RE: Response Letter to Comments

Project Name: Take 5 Car Wash

We received the comments for the ICWG Central and Eubanks project; Please see below for our responses to the received comments.

C-8.0

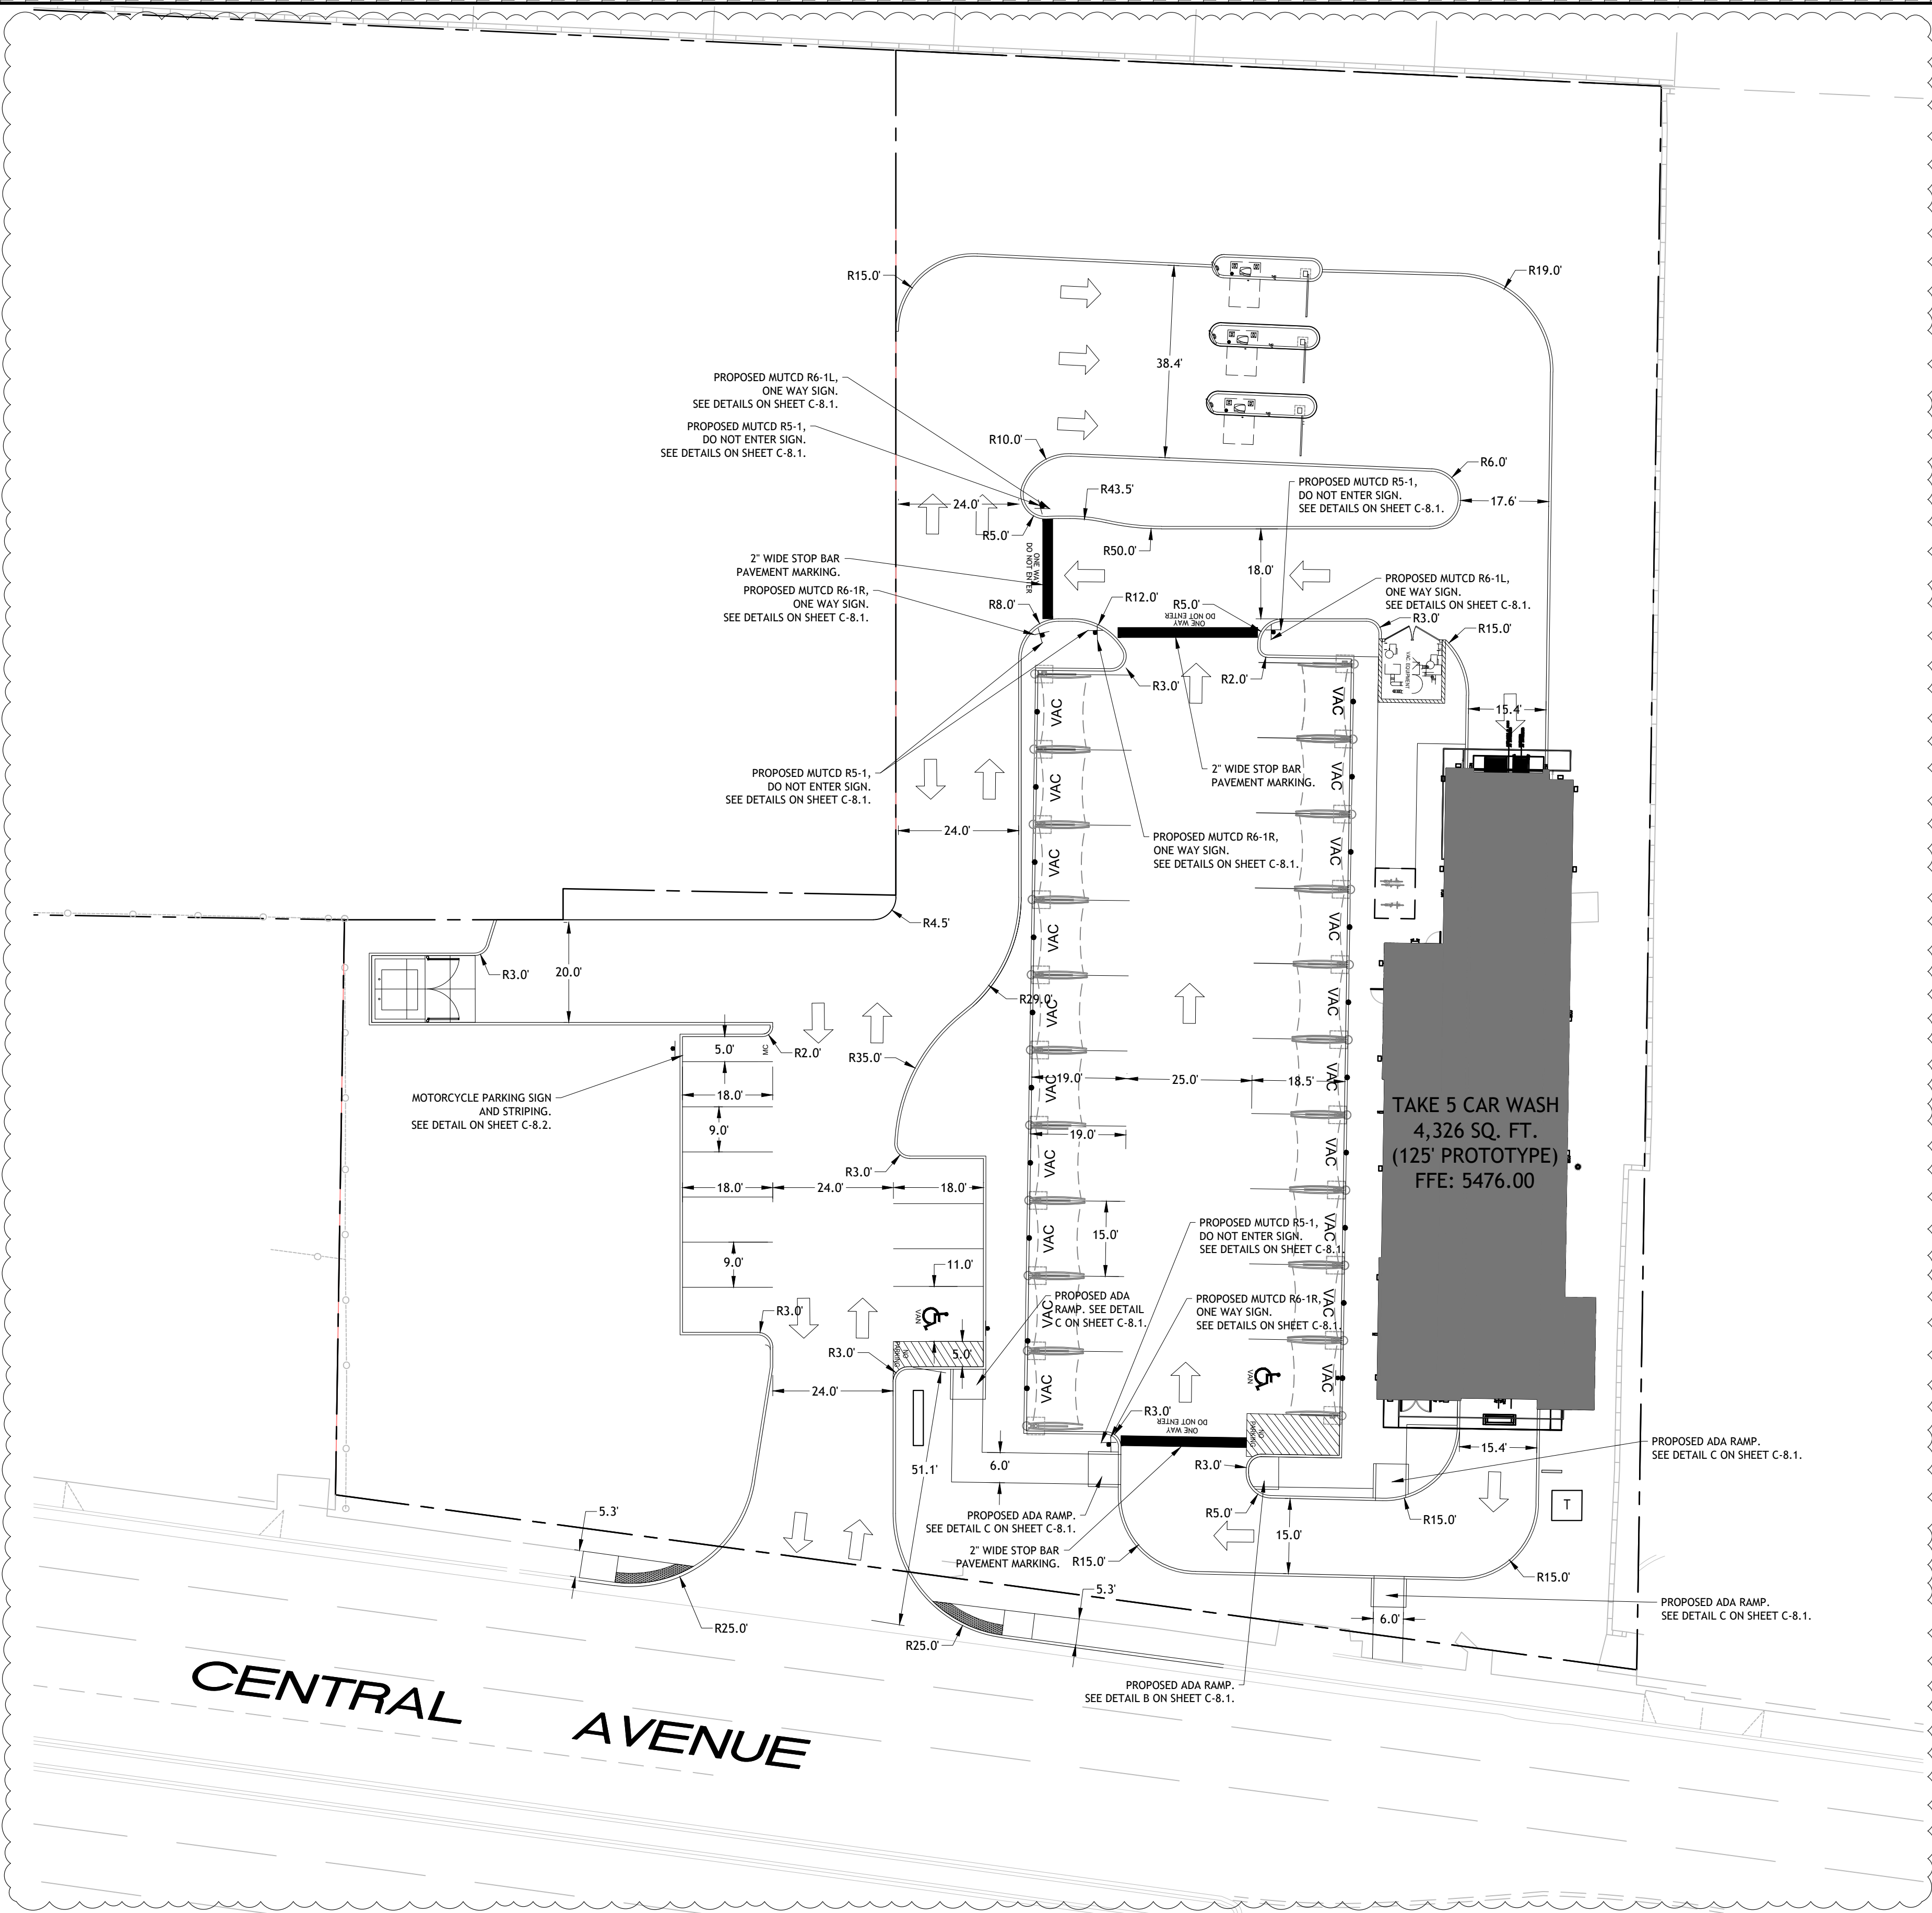
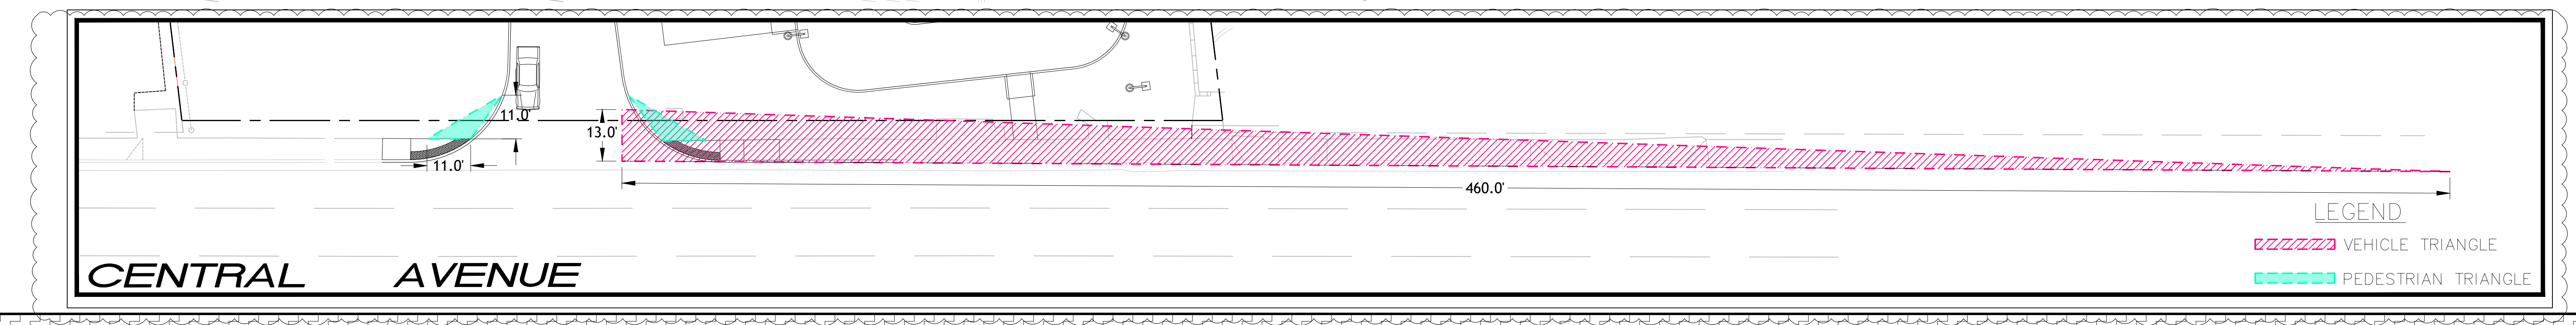
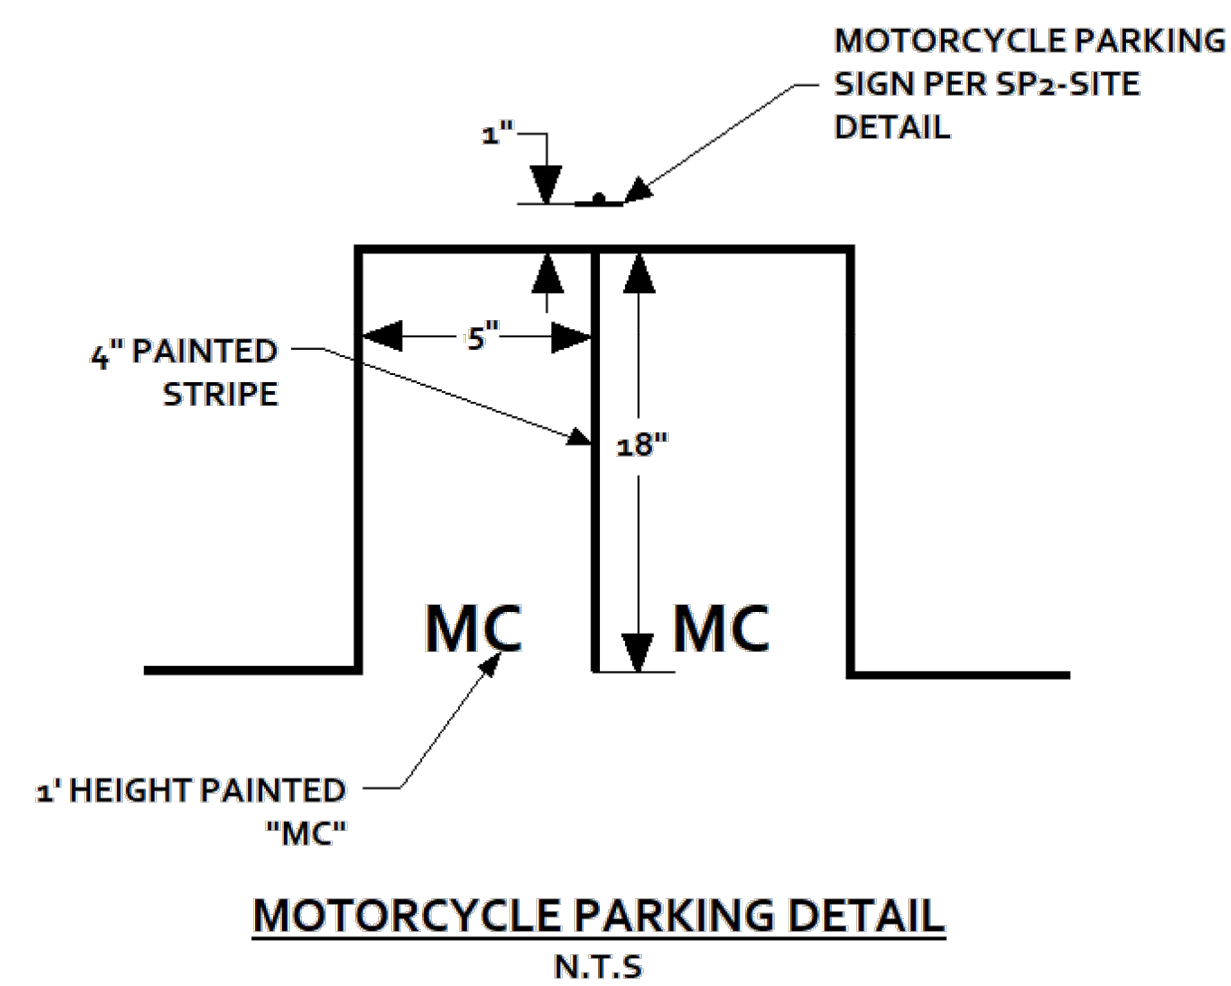
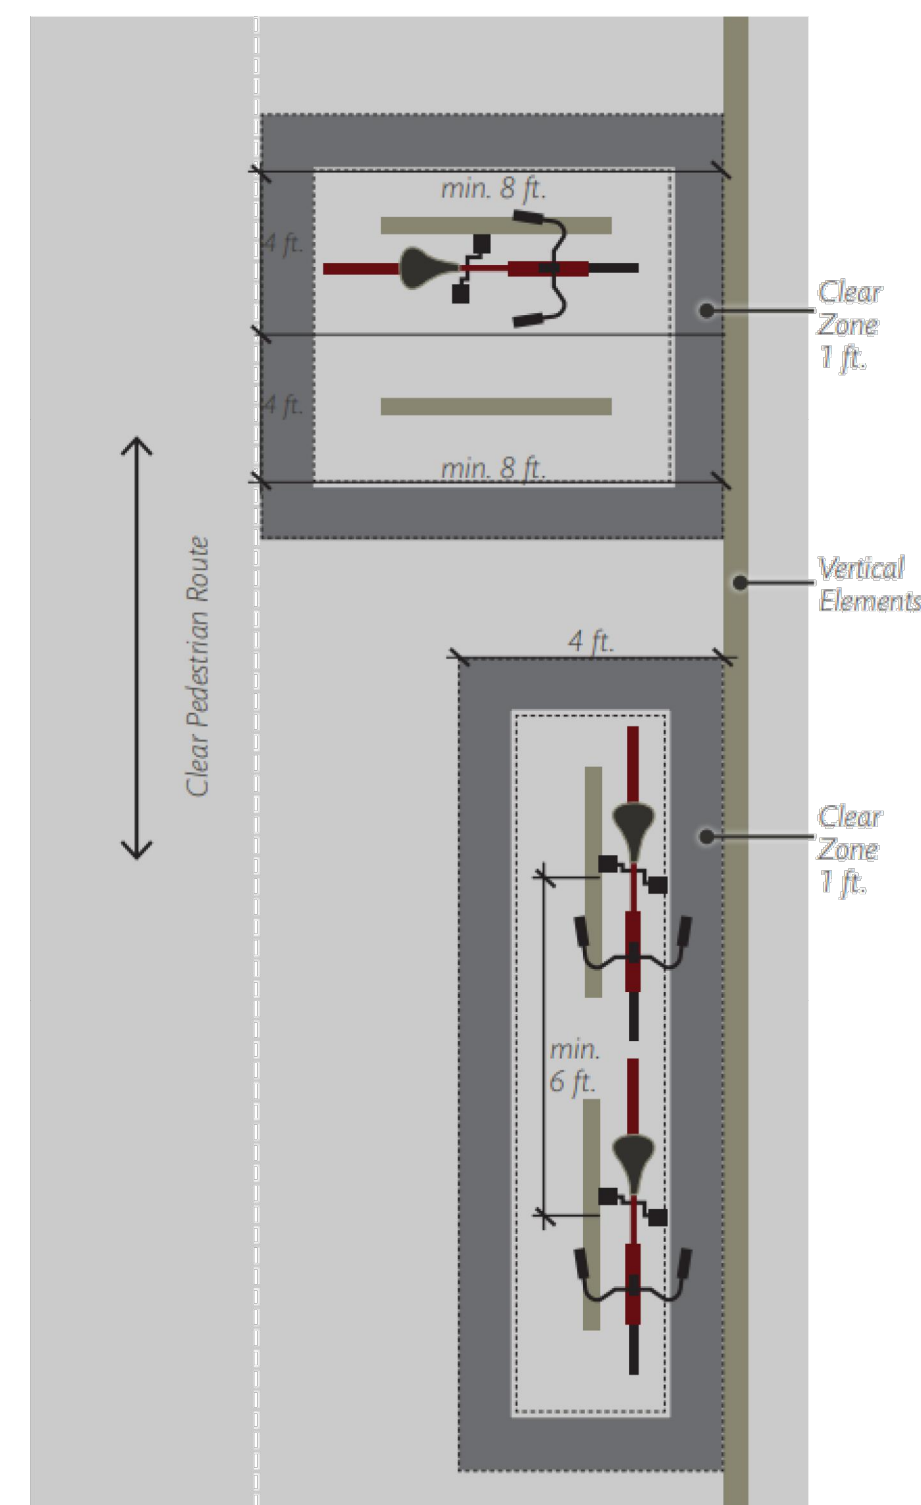
4. Site access's throat length should be minimum 50 ft. please show this dimension on the site plan.

6. ADA curb ramps at the driveway access must be updated to current standards and have truncated domes installed.

8. The ADA accessible aisle shall have the words “**NO PARKING**” in capital letters, each of which shall be at least one foot high and at least two inches wide, placed at the rear of the parking space so as to be close to where an adjacent vehicle’s rear tire would be placed. (66-1-4.1.B NMSA 1978)

9. Motorcycle parking spaces shall be designated by its own conspicuously posted upright sign, either free-standing or wall mounted per the zoning code.
 10. The pavement marking “MC” should be shown in the opposite direction for motorcycles entering the parking space.

13. A 1-foot clear zone around the bicycle parking stall shall be provided.

14. Bicycle parking spaces shall be at least 6 feet long and 2 feet wide.

15. List radii for all curves shown; for passenger vehicles. Radius for delivery trucks, fire trucks, etc. is 25 ft. or larger.

16. Per the IDO, a 6ft wide ADA accessible pedestrian pathway is required from the public sidewalk to the building entrances. Please clearly show this pathway and provide details.

17. Per DPM, a 6 ft. wide ADA accessible pedestrian pathway is required from the ADA parking stall access aisles to the building entrances. Please clearly show this pathway and provide details.

18. ADA accessible pedestrian pathway should not be placed behind parking spaces or adjacent to a vehicular way. Vehicle and pedestrian/wheel chair conflicts should be avoided as much as possible.

19. Refuse vehicle maneuvering shall be contained on-site. The refuse vehicle shall not back into the public right of way; provide a copy of refuse approval.

23. Clear Sight Triangle should start from the back of the sidewalk.

Response: The site access's throat length is more than 50 ft. The dimension has been provided on Sheet C-8.0 Circulation Plan.

Response: ADA curb ramps with truncated domes at the driveway access have been updated to current standards. Sheet C-8.0 Circulation Plan. Ramp details can be found on Sheet C-8.1 Site Details.

Response: The ADA accessible aisles have been updated so as to show the words “NO PARKING” at the rear of the parking spaces. Sheet C-8.0 Circulation Plan.

Response: Motorcycle parking has been provided and a sign location and “MC” pavement parking have been proposed. Sheet C-8.0 Circulation Plan.

Response: A 1-foot clear zone around the bicycle parking stall has been provided. See Sheet C-8.0 Circulation Plan for bike pad dimensions.

Response: Bicycle parking spaces meet the length and width requirements. See Sheet C-8.0 Circulation Plan for bike pad dimensions.

Response: All radii dimensions have been provided on Sheet C-8.0 Circulation Plan.

Response: A 6ft wide ADA accessible pedestrian pathway has been proposed from the public sidewalk to the building entrances. Sheet C-8.0 Circulation Plan.

Response: A 6ft wide ADA accessible pedestrian pathway has been proposed from the public sidewalk to the building entrances. Sheet C-8.0 Circulation Plan.

Response: ADA accessible pedestrian pathway should not be placed behind parking spaces or adjacent to a vehicular way. Sheet C-8.0 Circulation Plan.

Response: Refuse vehicle maneuvering will be contained on-site. Sheet C-8.0 Circulation Plan. A copy of the refuse approval shall be submitted.

Response: The Sight Triangles have been updated on Sheet C-8.0 Circulation Plan.
